Subject: 658 Truelove Road
Holly Springs, NC 27540
Detached Garage Masonry Walls Letter
Harnett County Permit #: BRES2301-0006

Based on the request of the Contractor, I reviewed the height of the masonry walls of the Detached Garage for code compliance. My assessment is as follows:

**ELEVATIONS**  
SCALE: 1/4" = 1'-0"

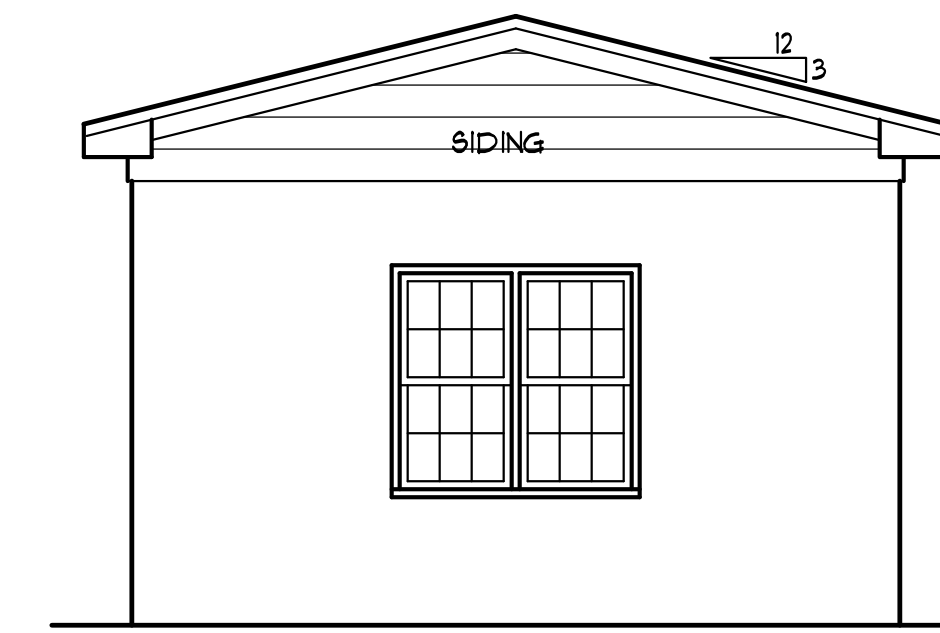
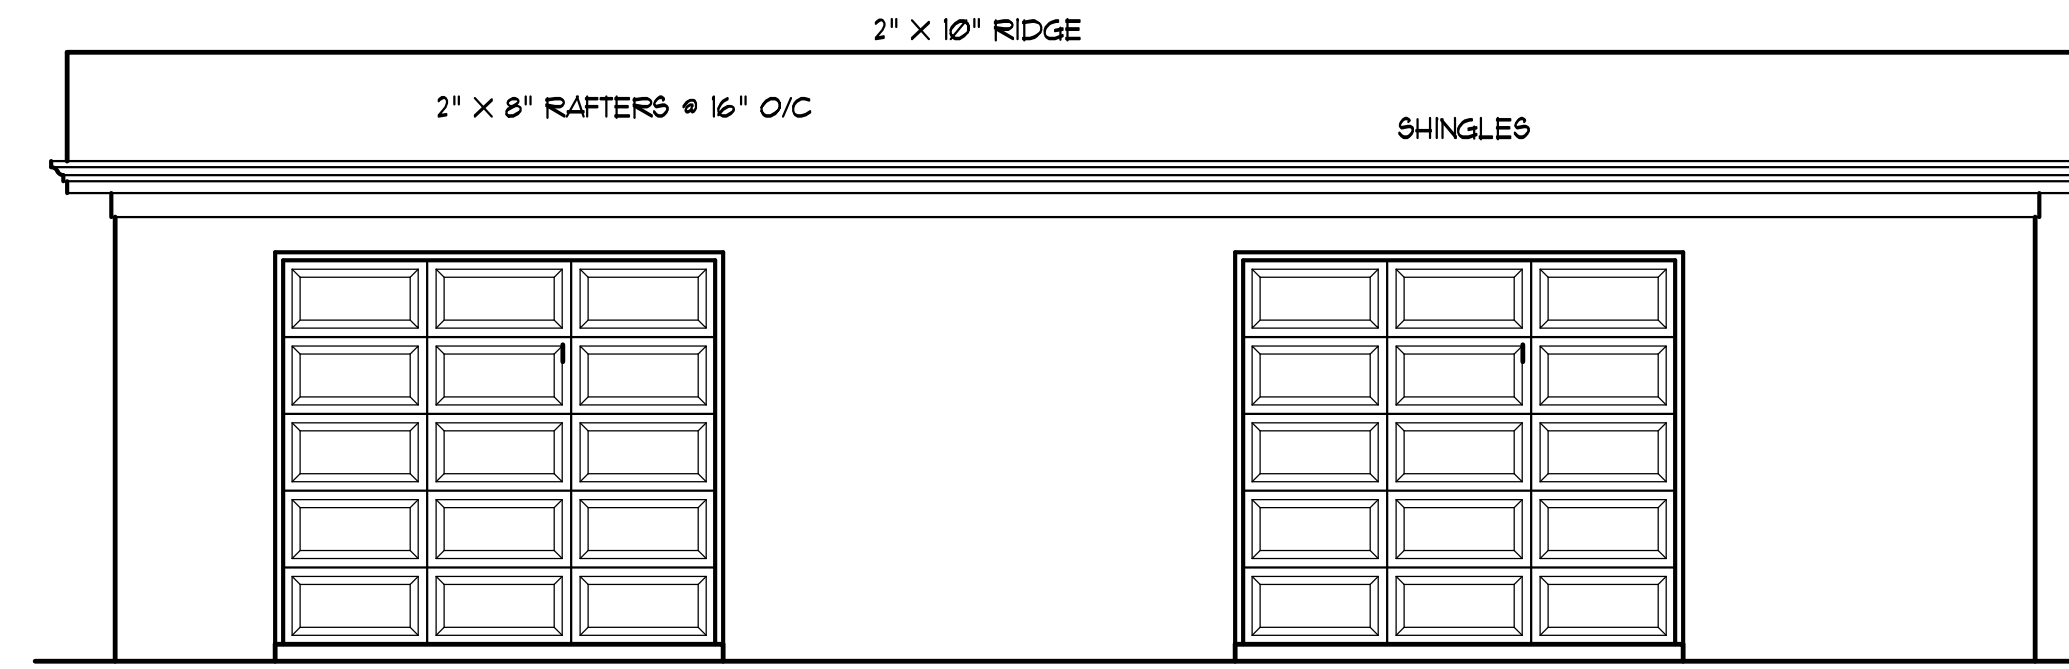
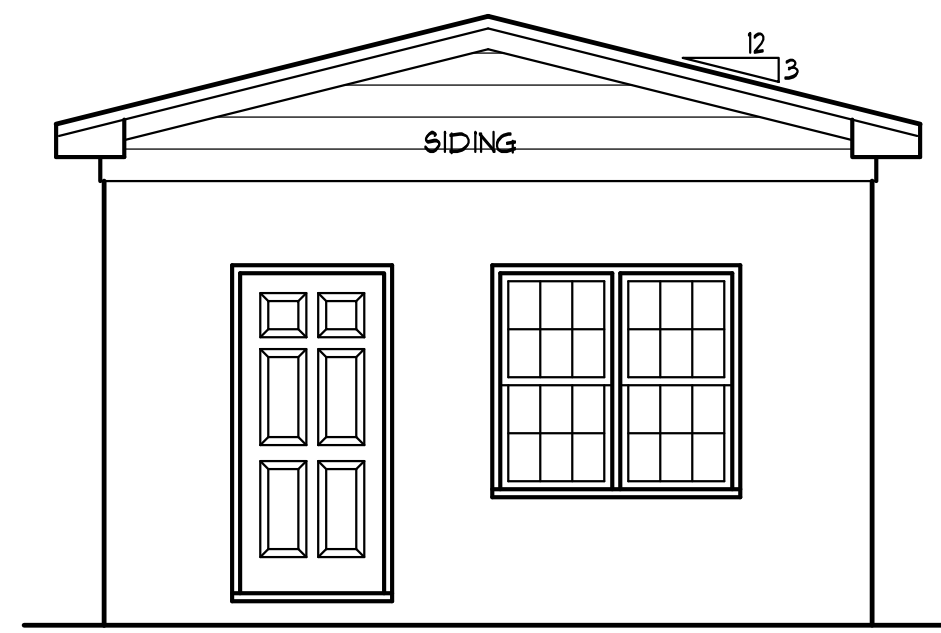
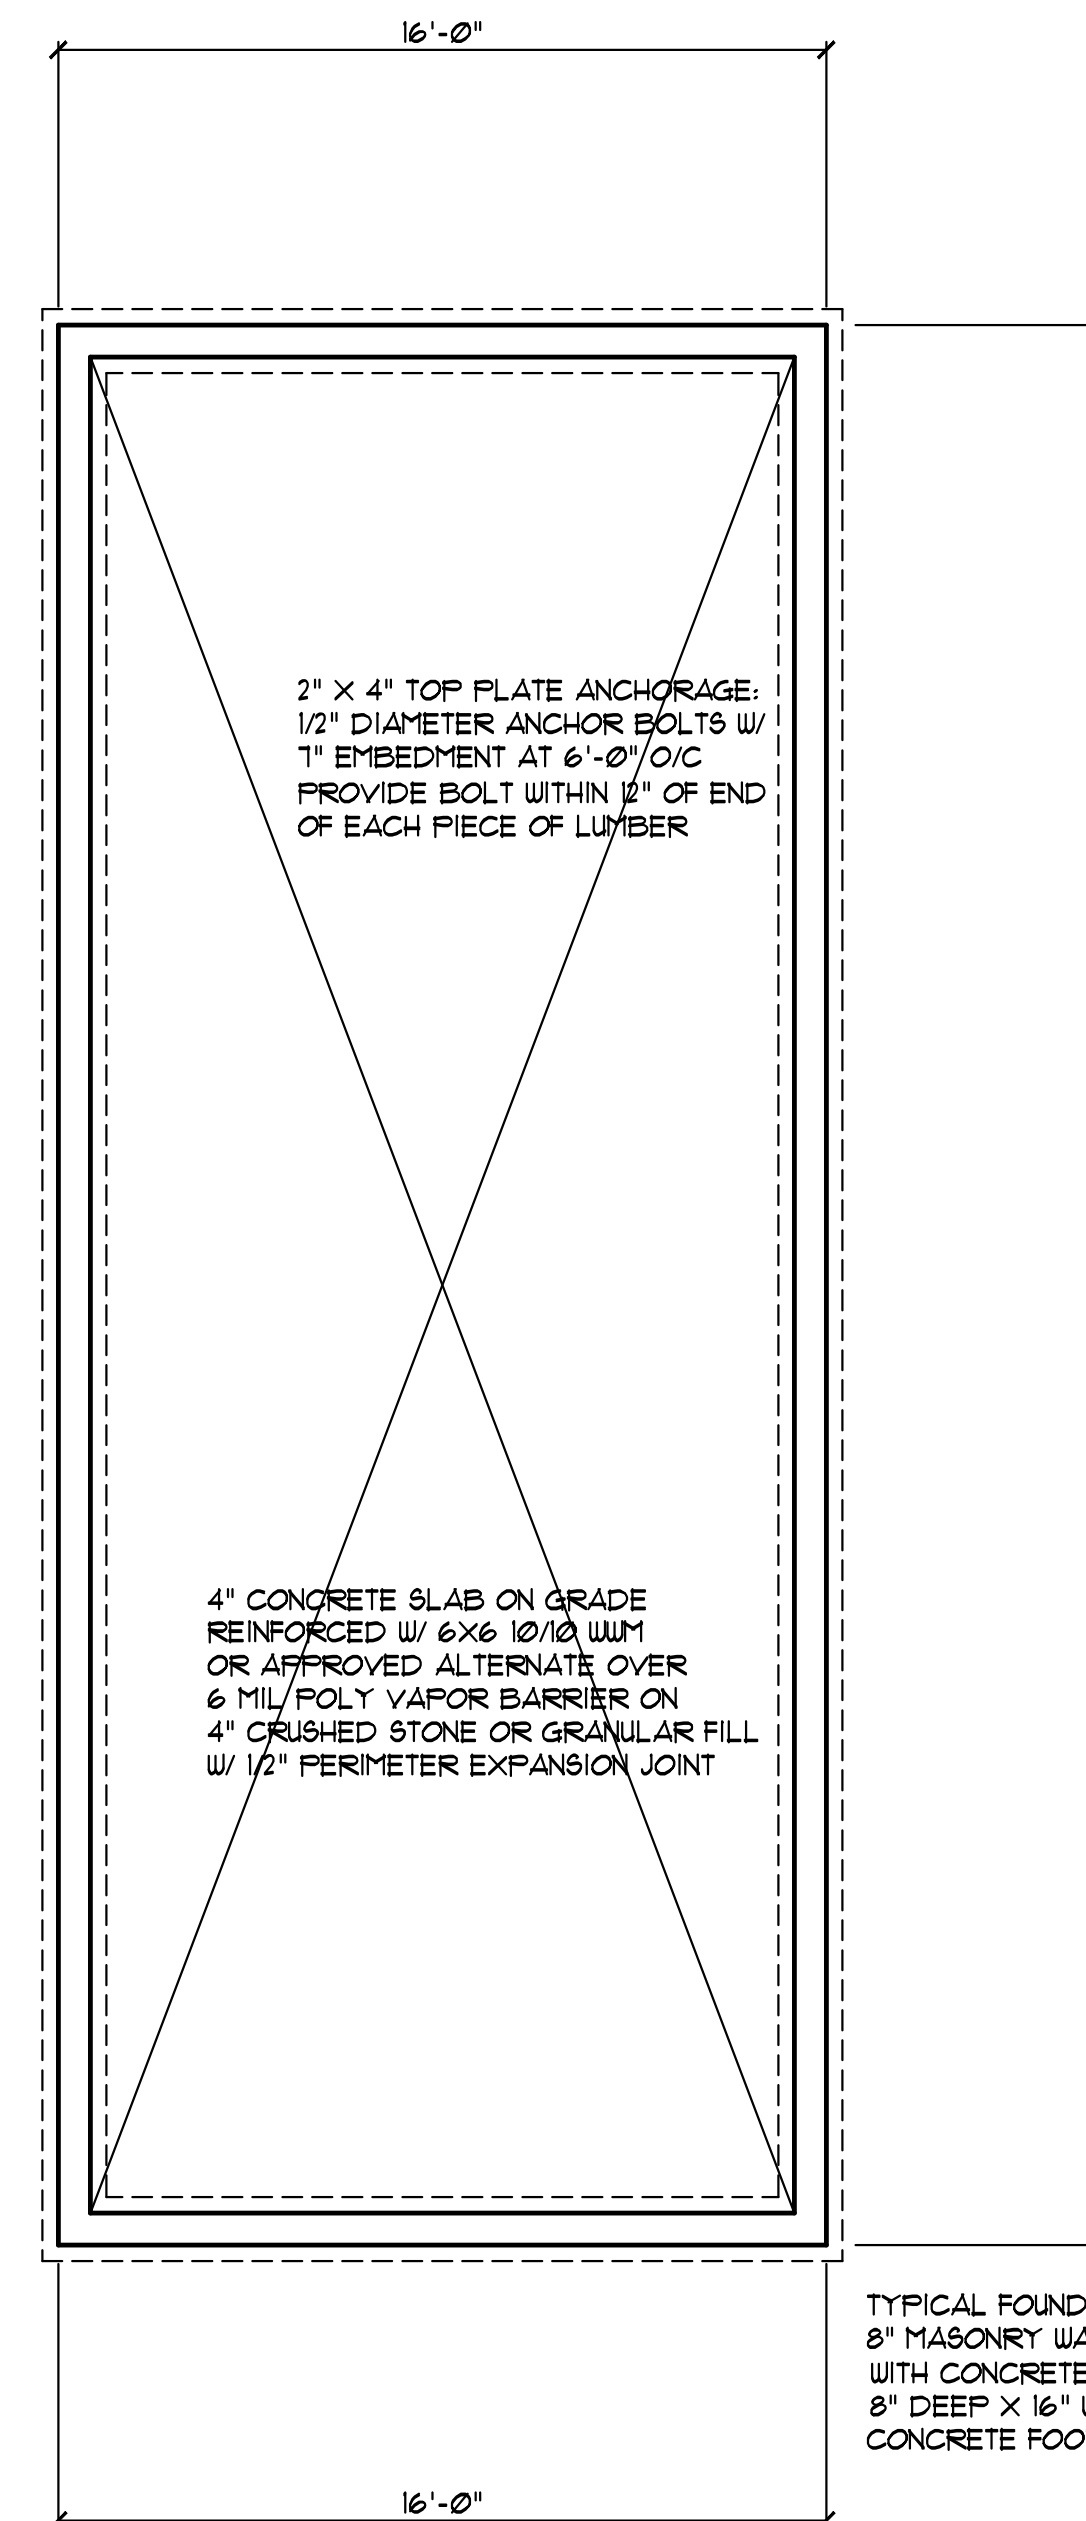
- The walls of the detached garage are 8"x 8"x 16" concrete masonry units on concrete footings. The walls are 11' tall from the top of the concrete footings to the top of the wall. The 11' CMU walls are acceptable as constructed.

The masonry walls of the Detached Garage meet all the requirements of the 2018 North Carolina Building Code for Residences.
